SAND CREEK RESTORATION
POND PLANS

SHEET 41 OF 121
JOB NO. 25188.04

**LOW FLOW CHANNEL 1
STA 9+00.00 TO 19+00.00**
POND W-3
CROSS SECTION A-A
HORIZONTAL SCALE: 1"=50'

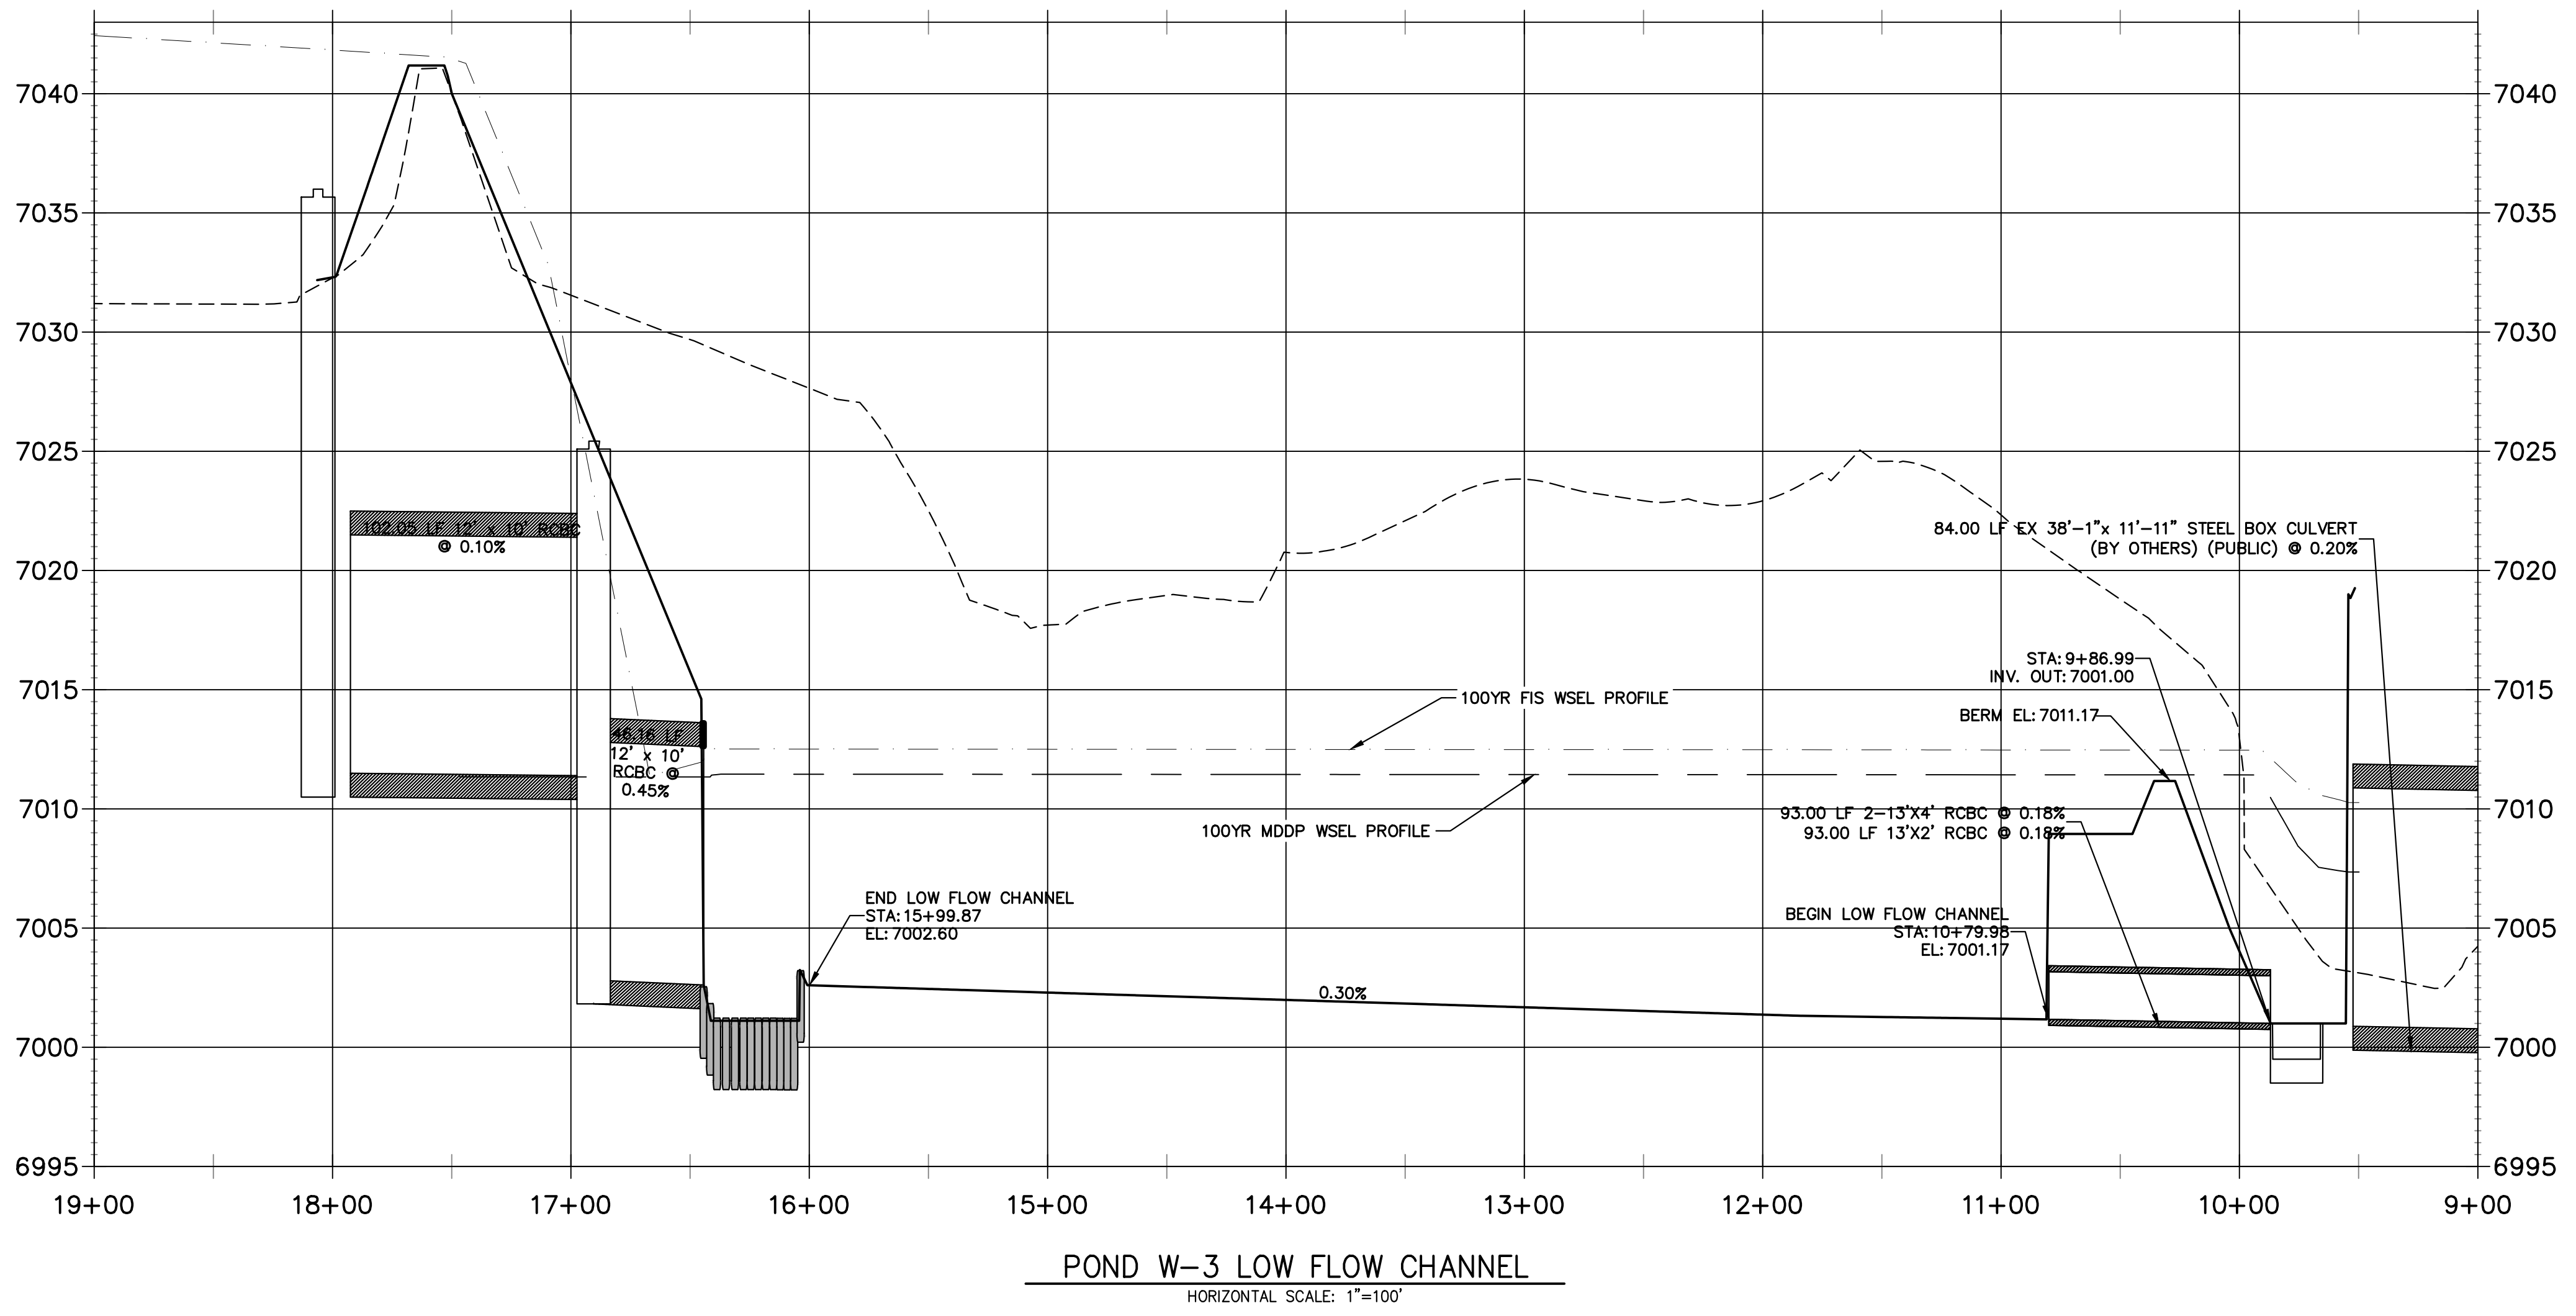
Why is this pointed now?

SRMD POND #1 SECTION A-A PROFILE

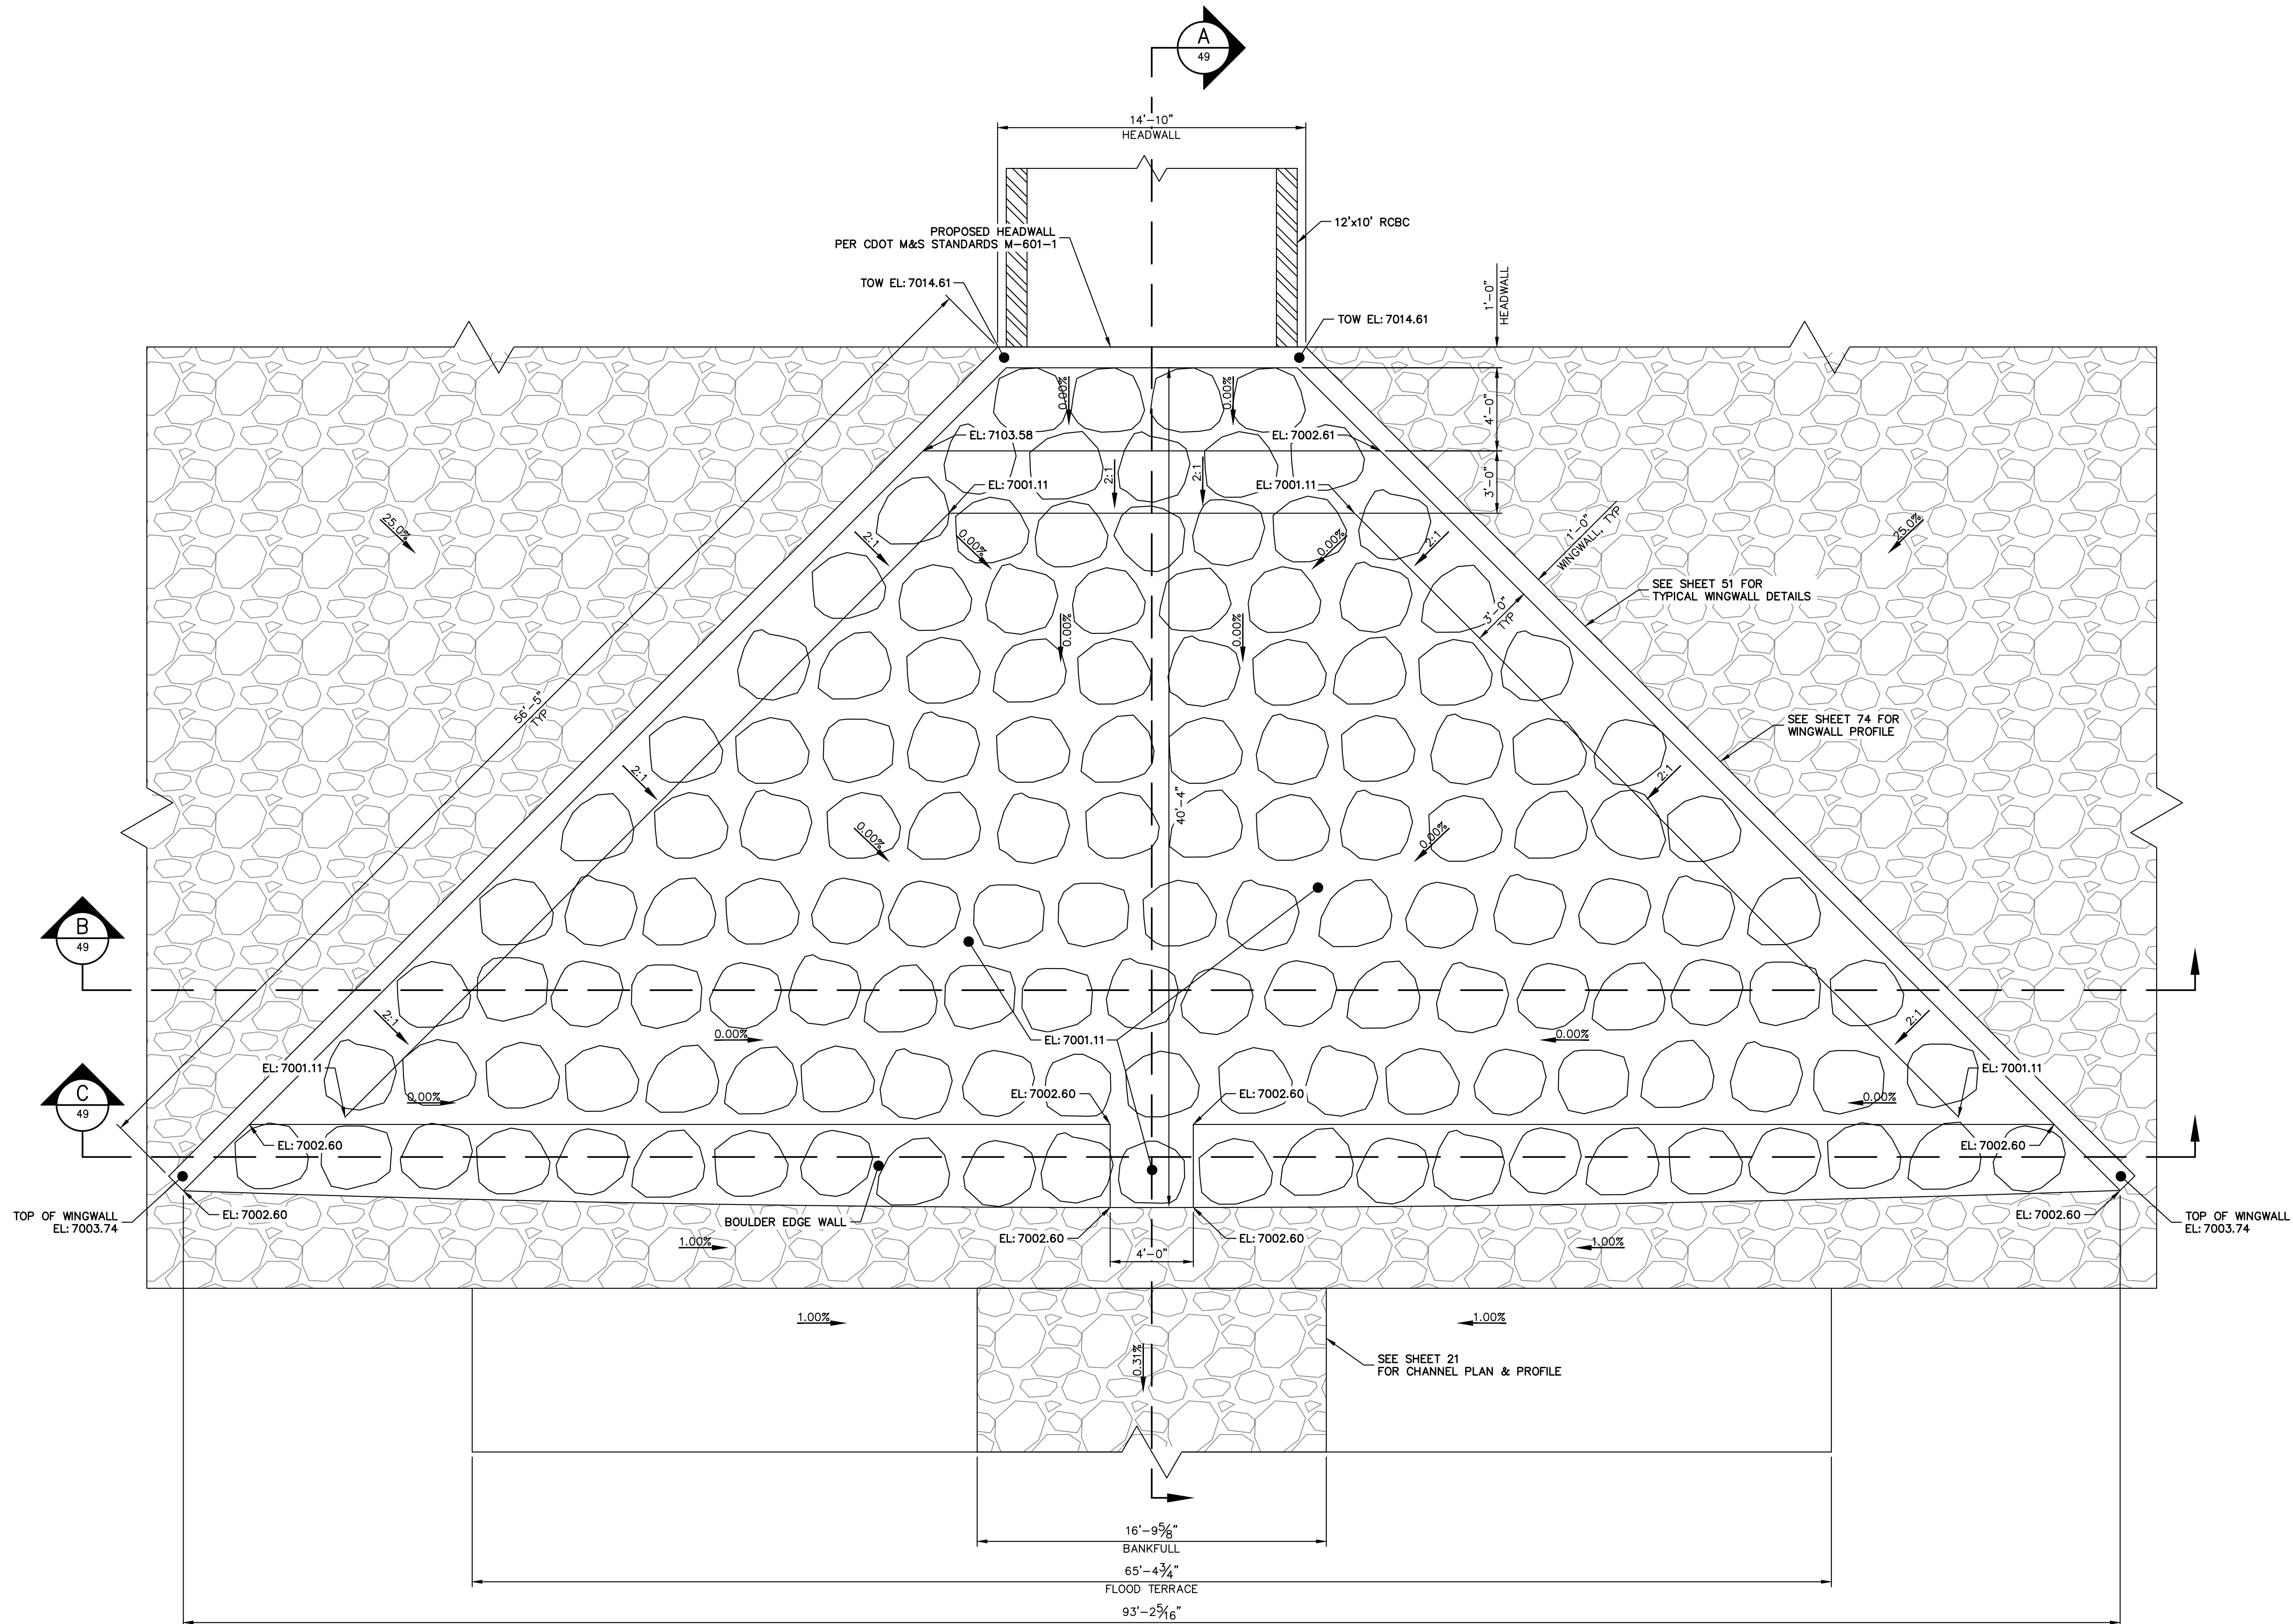
Is there a riffle drop detail?
